**East Yorkshire Solar Farm
EN010143**

**Statement of Common Ground between East Yorkshire Solar
Farm Limited and the Ouse and Derwent Internal Drainage
Board**

Document Reference: EN010143/APP/8.16

15 August 2024
Revision Number: 01

FIGURE TITLE
Drain Names
Sheet 2 of 3

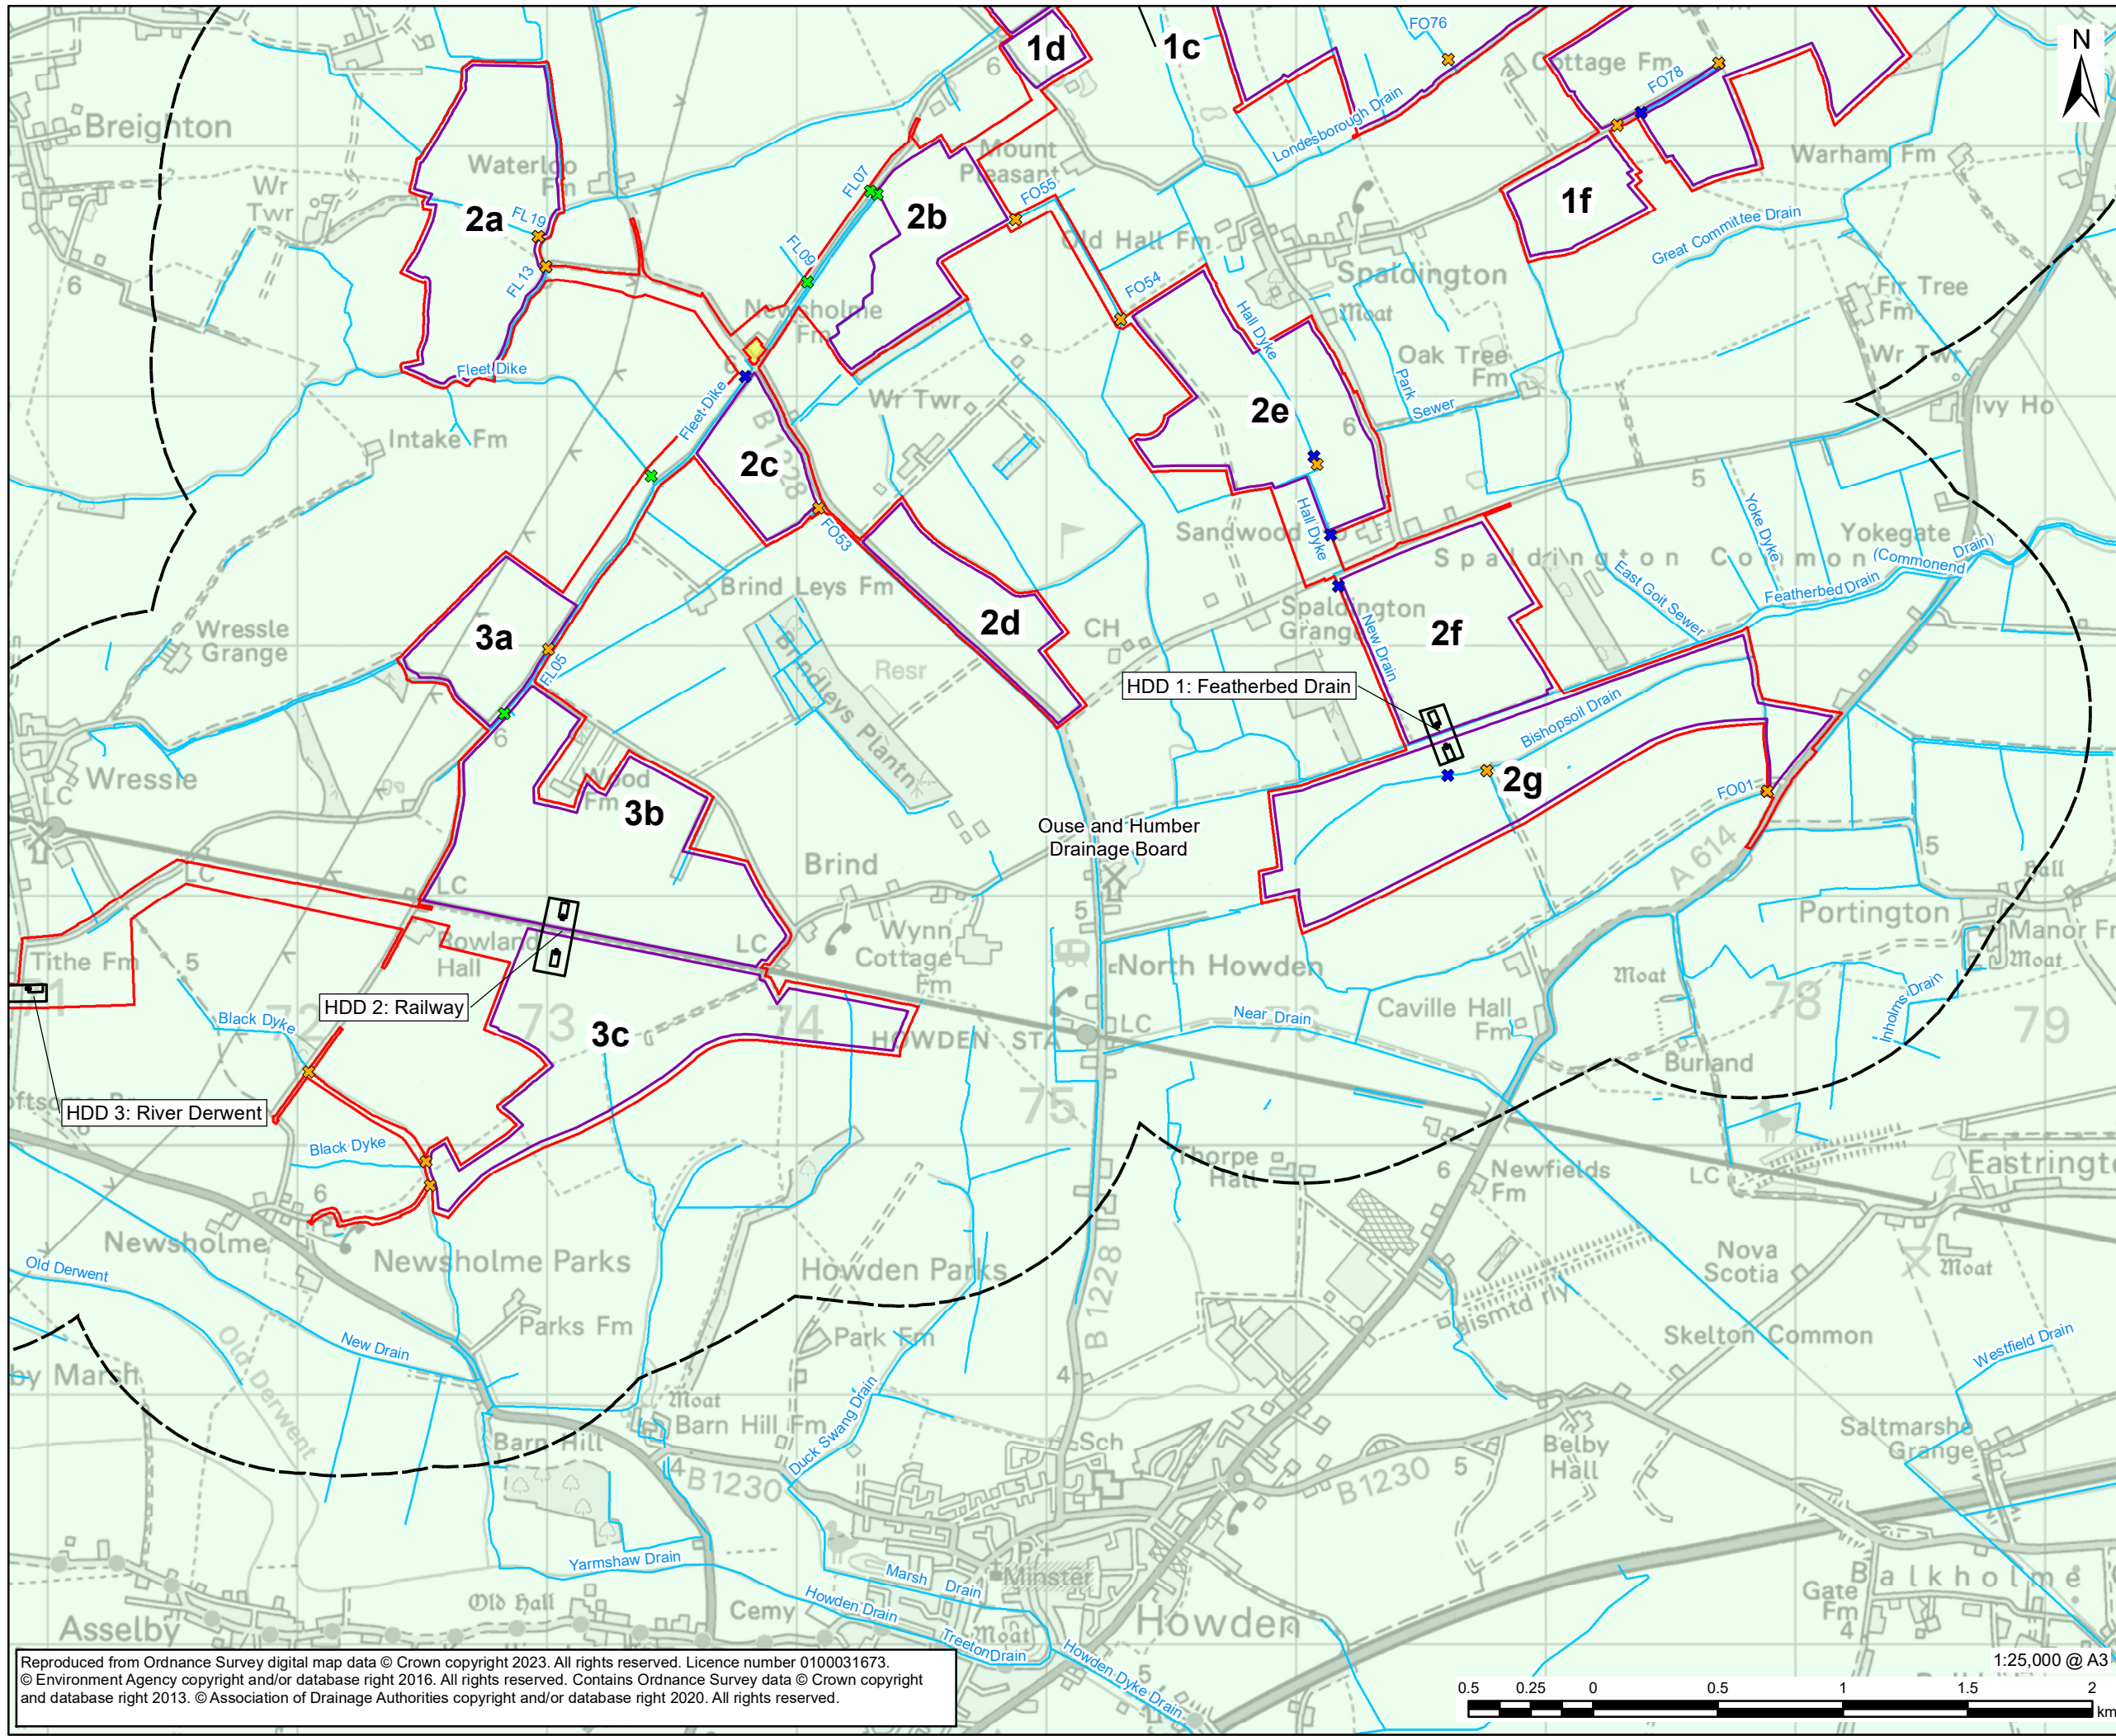
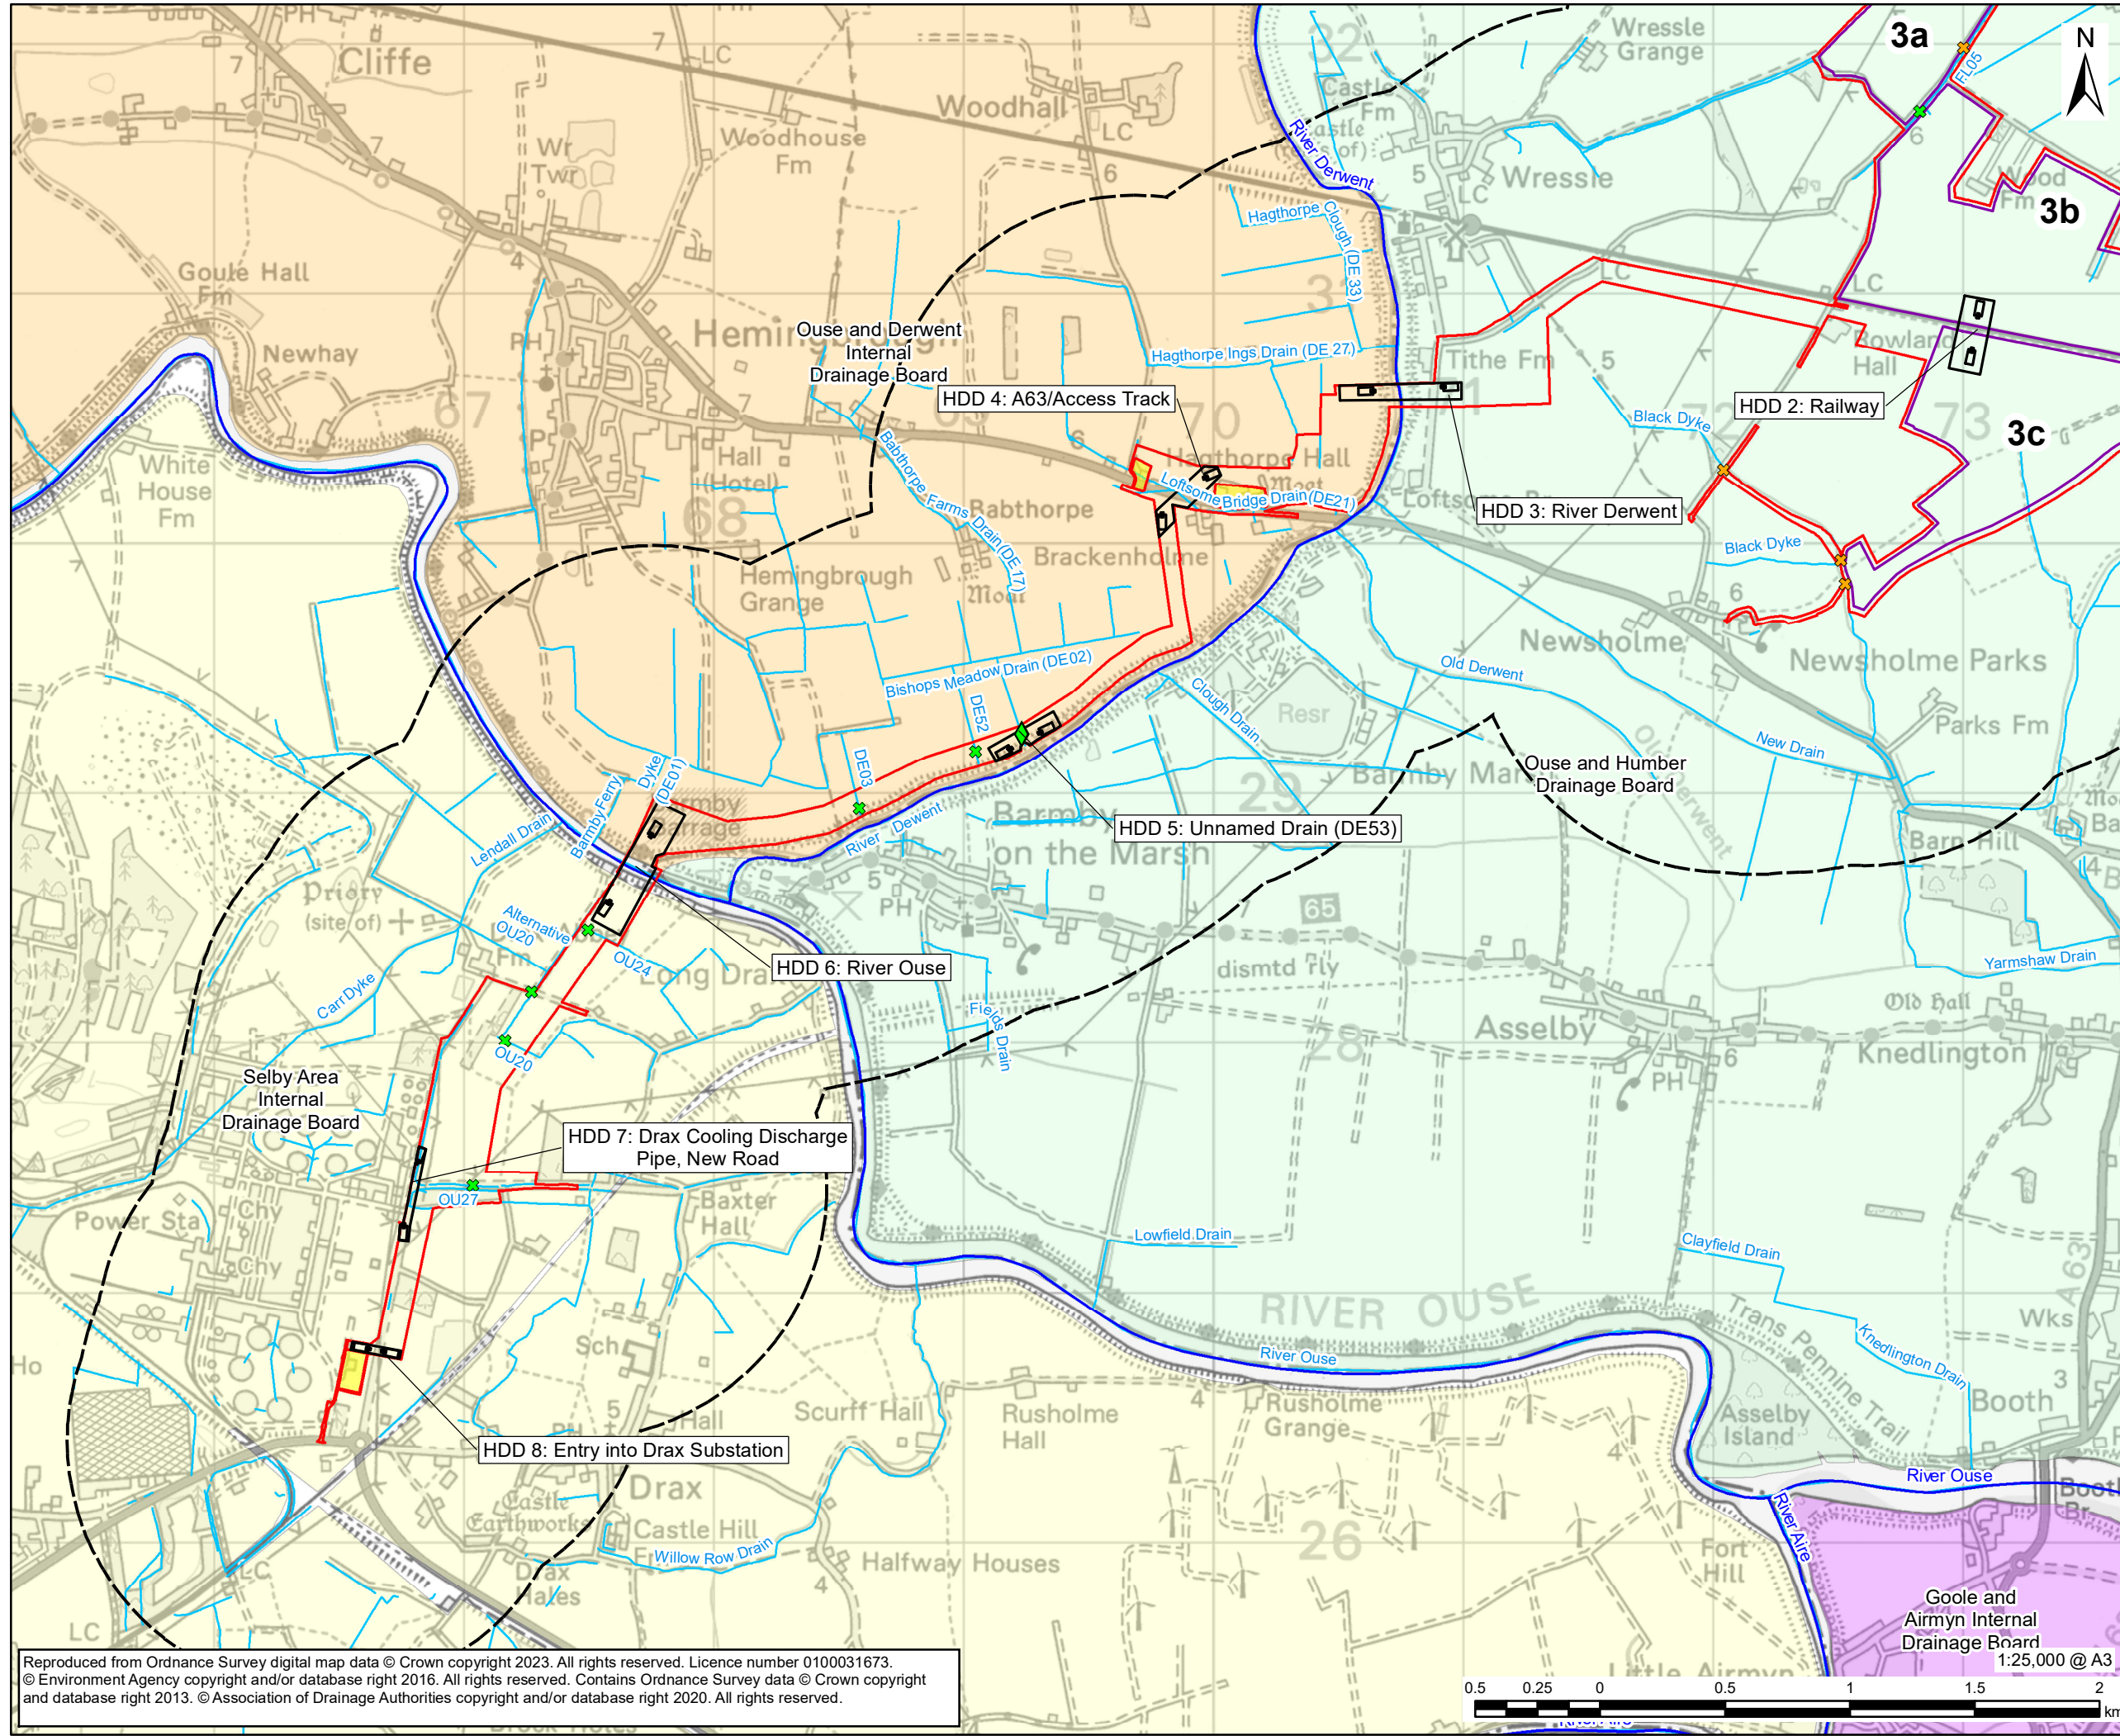
Ref	Relevant Application Document	Summary of Description of Matter	Ouse and Derwent IDB Current Position	Applicant Current Position	Status
3.1.3	Relevant Representation	Relevant watercourses	<p>The Ouse and Derwent IDB note that using Figure 9-2: Drain Names (Sheet 3 of 3), ES Volume 3 [APP-152], the Ouse and Derwent IDB will be looking at the below watercourses which may/will be affected:</p> <p>1. Drain DE21 – this is the Ouse and Derwent IDB maintained watercourse known as Loftsome Bridge Drain.</p>	The Applicant accepts that the Ouse and Derwent IDB will be looking at the watercourses identified in their relevant representation.	Agreed

Ref	Relevant Application Document	Summary of Description of Matter	Ouse and Derwent IDB Current Position	Applicant Current Position	Status
			<p>2. Drain DE53 – this is the Ouse and Derwent IDB maintained watercourse known as Bishops Clough Drain. The Ouse and Derwent IDB’s pumping station is downstream, prior to the outfall into the River Derwent.</p> <p>3. Drain DE52 – this is an ordinary watercourse not maintained by the Ouse and Derwent IDB but by the riparian owner.</p> <p>4. Drain DE03 – this is an ordinary watercourse not maintained by the Ouse and Derwent IDB but by the riparian owner.</p>
